From: Simon Davis
Sent: 05 February 2024 17:03
To: [REDACTED]
Subject: RE: BR/97/22/PL Royal Bay

From: Simon Davis
Sent: Monday, February 5, 2024 12:48 PM
To: [REDACTED]
Subject: BR/97/22/PL Royal Bay

Royal Bay (Application Reference BR/97/22/PL) - External Amenity Areas

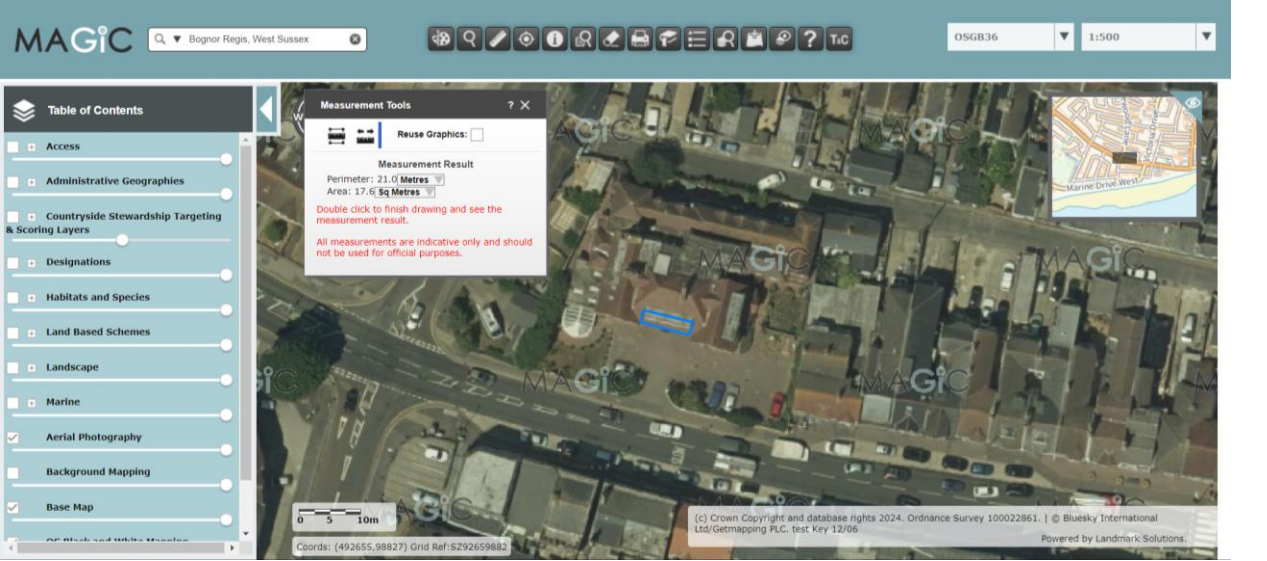
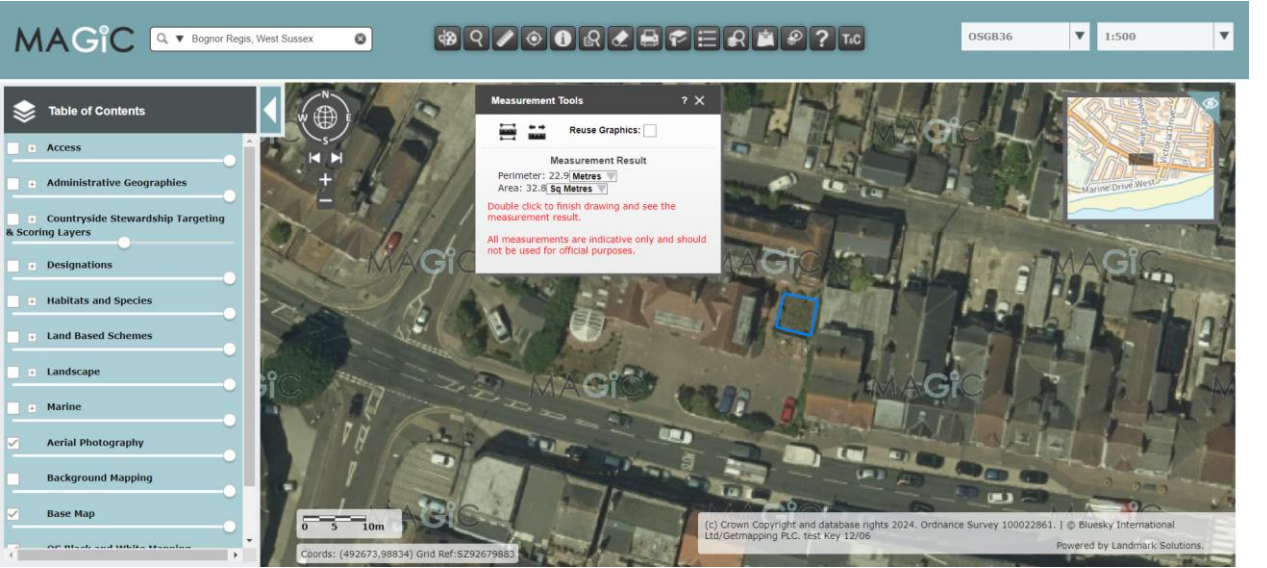
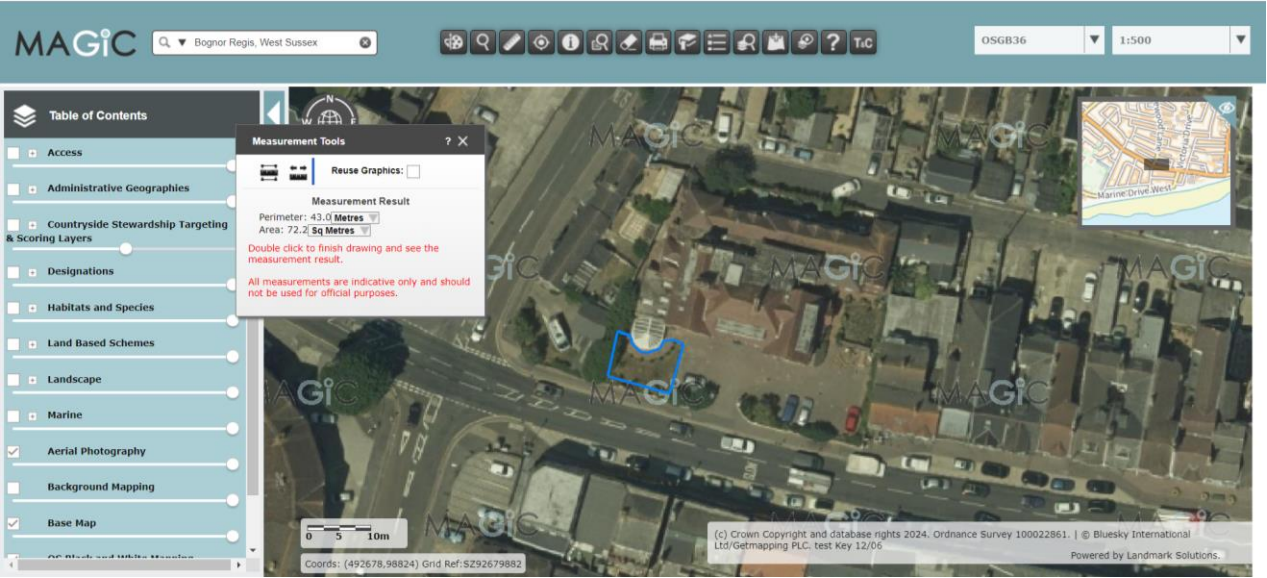
You have referred to the appeal decision at 83 Aldwick Road which stated 40m² should be the minimum communal amenity space. However, this was then also partly dismissed having regard to the quality of the space which was deemed too compact to be useable or enjoyable.

The appeal decision at Nyewood Lane referred to above ref Pagham Harbour also commented on this matter and made reference to some previous decisions where a lower m² of space per person had been accepted by the Council. The m² for the appeal proposal was 3.56m² per resident which exceeded some other sites including Ashley House (1.71m²) and indeed the temp permission for the Royal Bay Care Home (stated to be 0.7m² based on 41m²). It is unclear where the amount of 41m² comes from, but it may represent the rear area which is a compact space. Even if I now take your figure of 133m², then the figure is 2.22m² which is lower than the appeal decision.

I agree that you meet the minimum amount per the 83 Aldwick Road decision however given the other appeal decision and the comments on the former regarding the quality of the space, this is not a clear-cut issue. I will need to speak with my manager about this to agree our position.
